Traffic Impact Study_V1.PDF Markup Summary

TRAFFIC IMPACT STUDY

**Bent Grass Dunkin' Donuts
El Paso County, Colorado**

Figure 6
SITE DEVELOPMENT DISTRIBUTION
 (%): Overall
SITE-GENERATED
 AM / PM Peak Hour

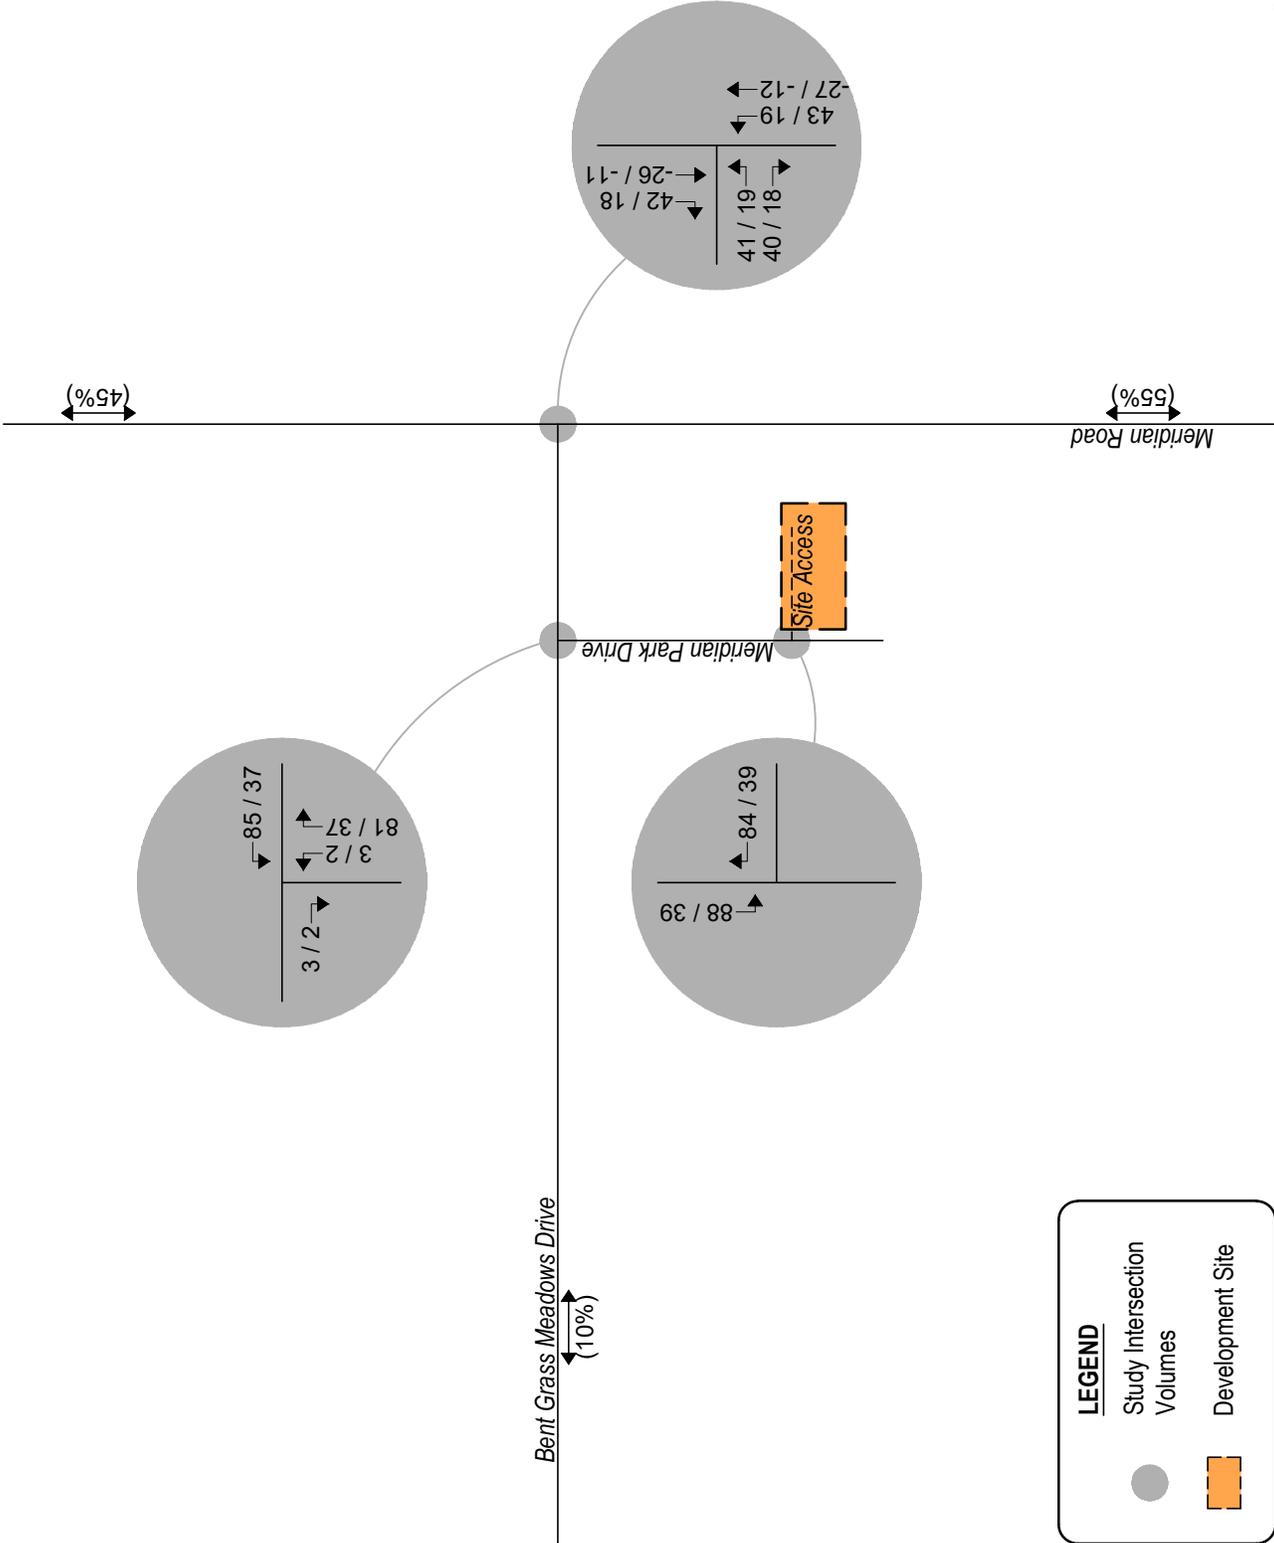
Provide analysis for dedicated painted left turn lane on Meridian Park Dr into development per ECM Section 2.3.7.D based am peak VPH. The 60ft ROW will support a dedicated turn lane.
